Case Officer: Lewis Knox

Applicant: Mr C Hall

Proposal: Erection of conservatory

DRAWING No. 1877 - 04.B

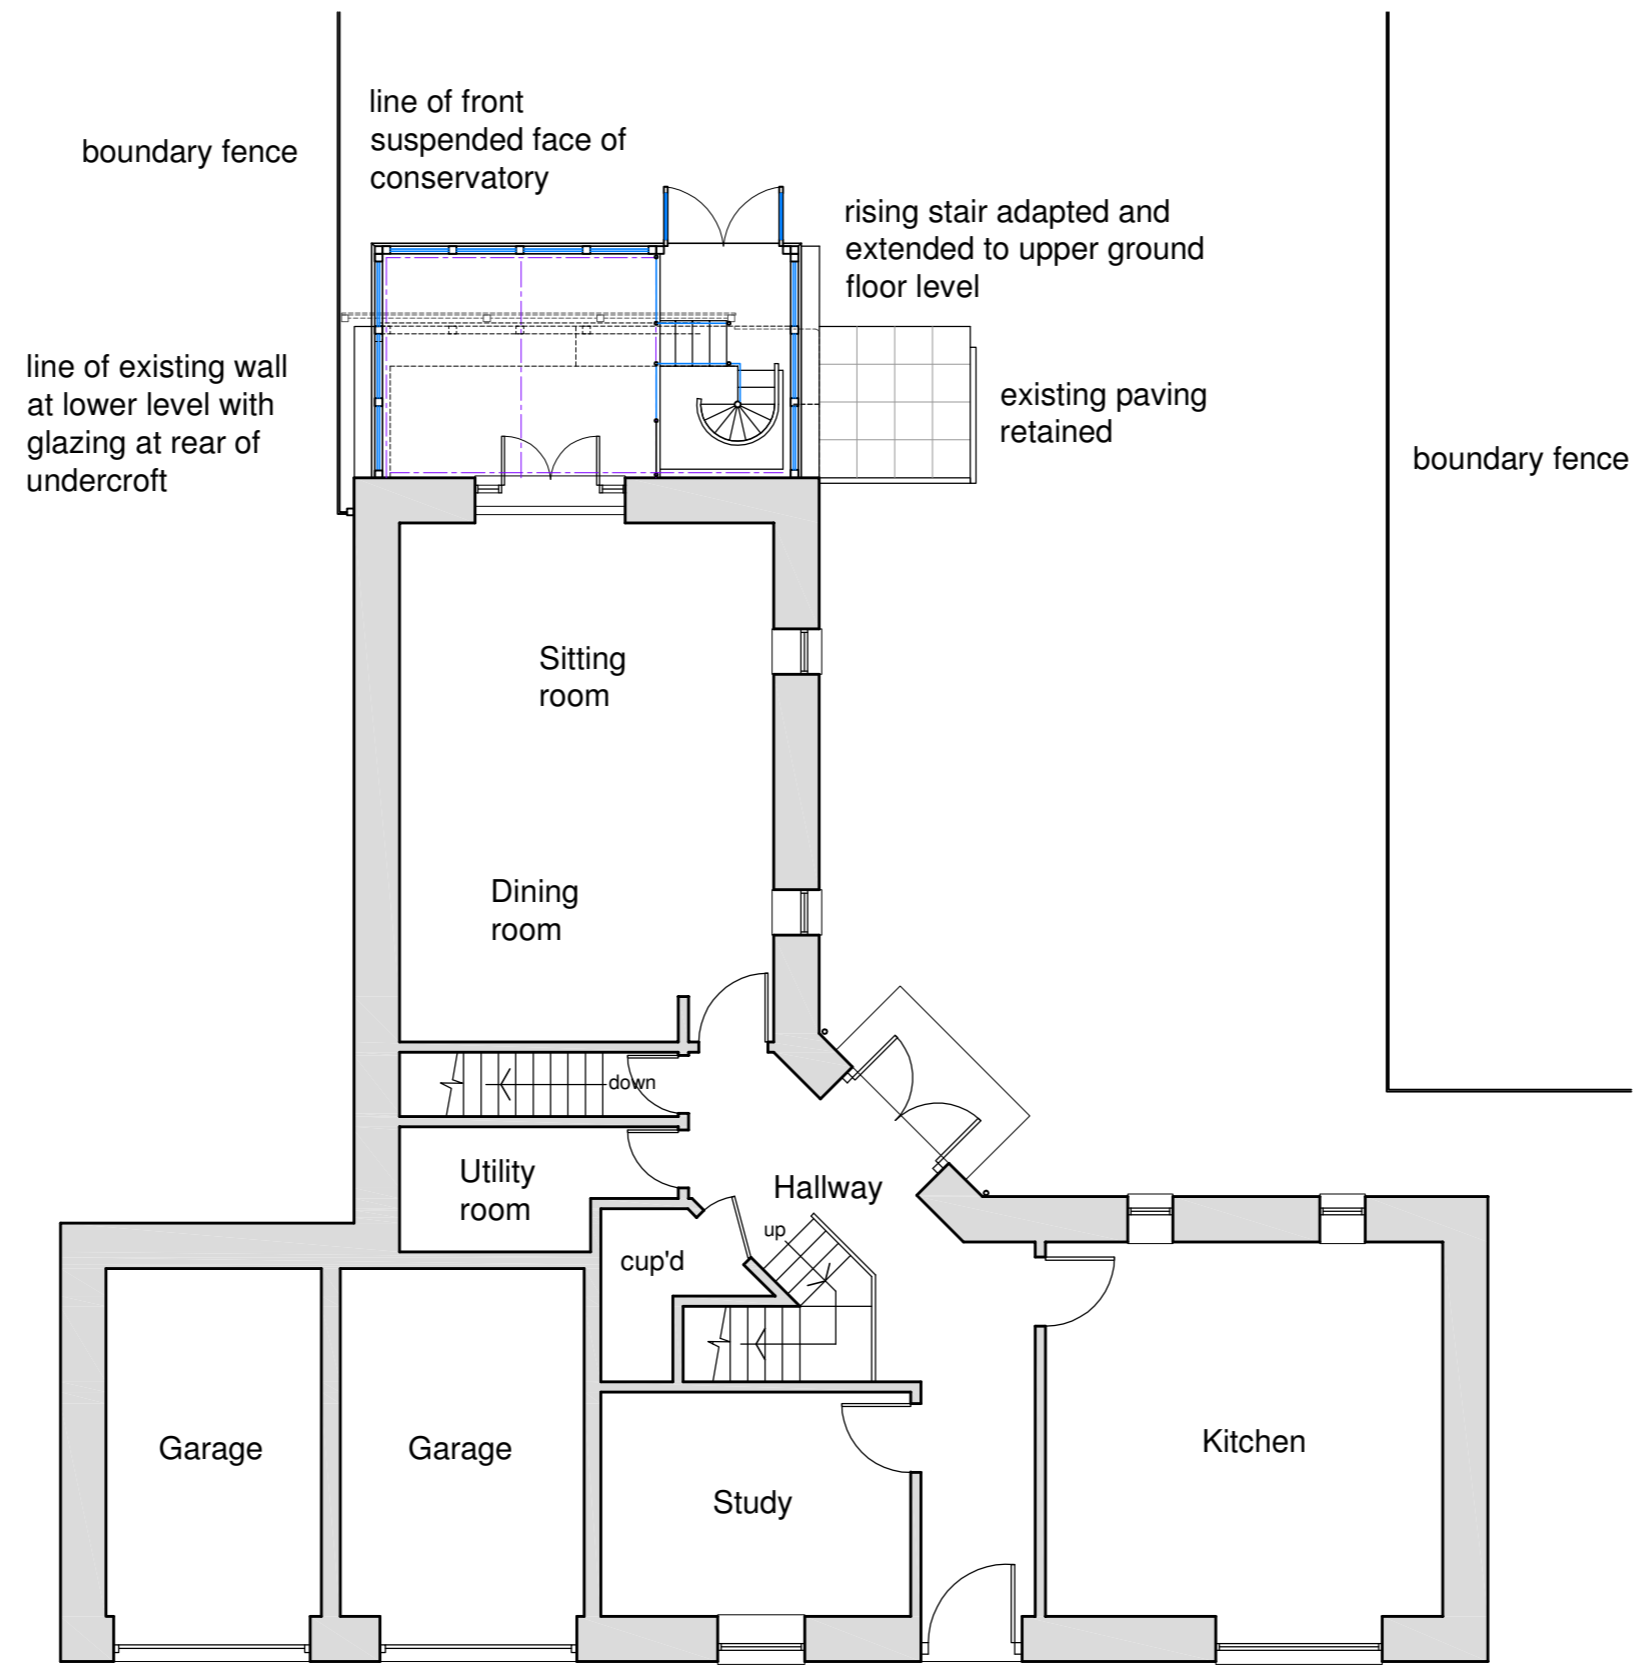
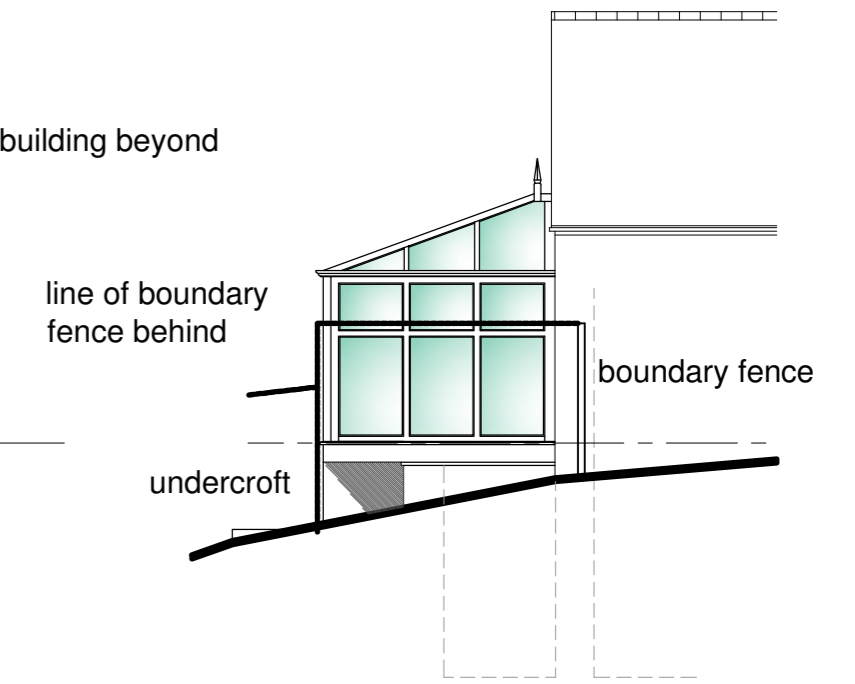
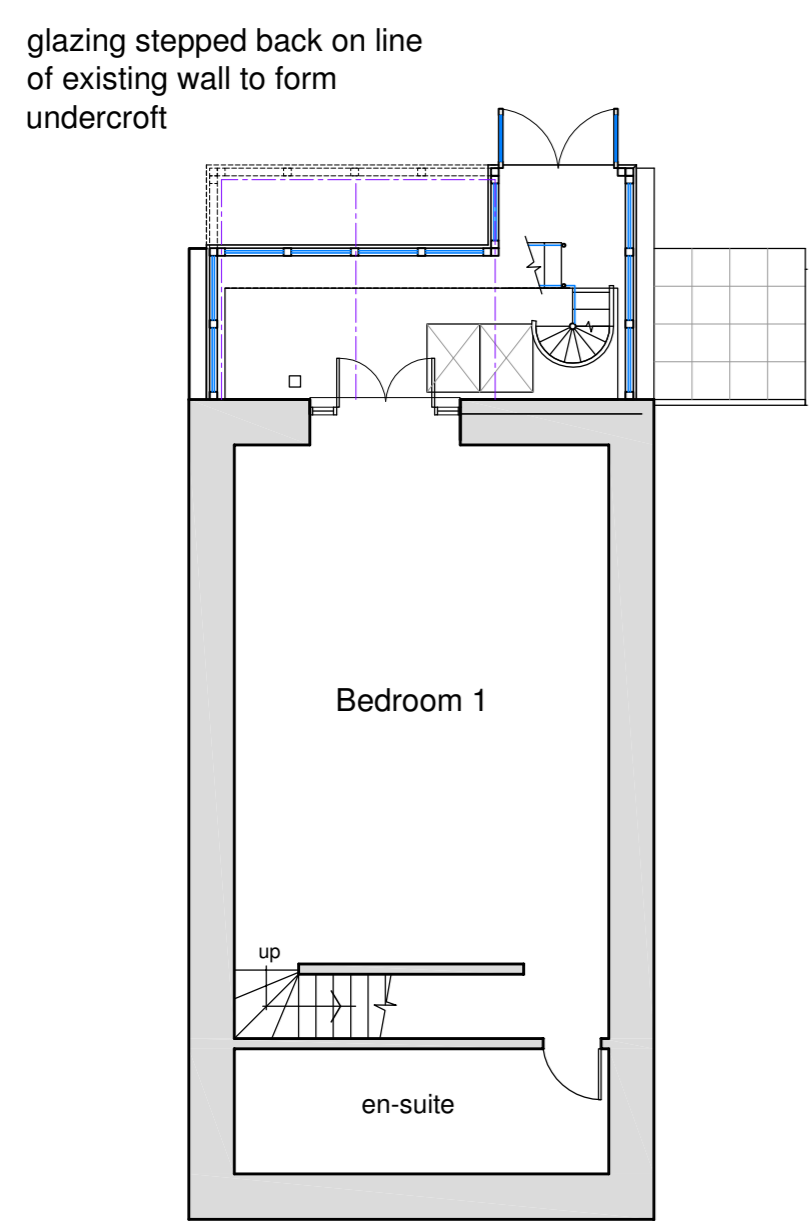
- Conservatories are typical features of residential properties such as this and as such it would accord with the existing character of the site.
- Concerns were raised over the appearance of the conservatory within the conservation area and the use of uPVC. Whilst the conservatory would be uPVC it would have the appearance of an oak framed structure, given the limited views from outside of the site, this is considered to be acceptable in this instance.

- Further concerns were raised regarding the structure covering up a large proportion of the natural stone elevation to the rear of the property. Whilst it would be somewhat obscured, the largely glazed nature of the conservatory would allow views into the original stone. Furthermore, the structure could easily be removed at a later date without causing harm to the character of the original dwelling. It is therefore considered that the harm caused in this respect would be minimal.

- Concerns were raised over a loss of privacy as a result of the largely glazed conservatory and that it would look directly towards the neighbouring dwelling at Jasmine Cottage. The conservatory would be set significantly away from the boundary with the southern neighbour; approx. 6.0m and so any potential immediate overlooking would be minimised.

- Furthermore, the conservatory would look towards a small area of the rear garden of the neighbouring property rather than facing any habitable rooms to the dwelling. Views to this garden would be obstructed by the boundary between the properties.

- It is also noted on the floor plan for the proposed conservatory that the area closest to the southern elevation of the conservatory would be a stair well to the lower ground floor and would not be available for occupants to sit and look out of, further decreasing the possibility of overlooking or loss of privacy to the southern neighbour.
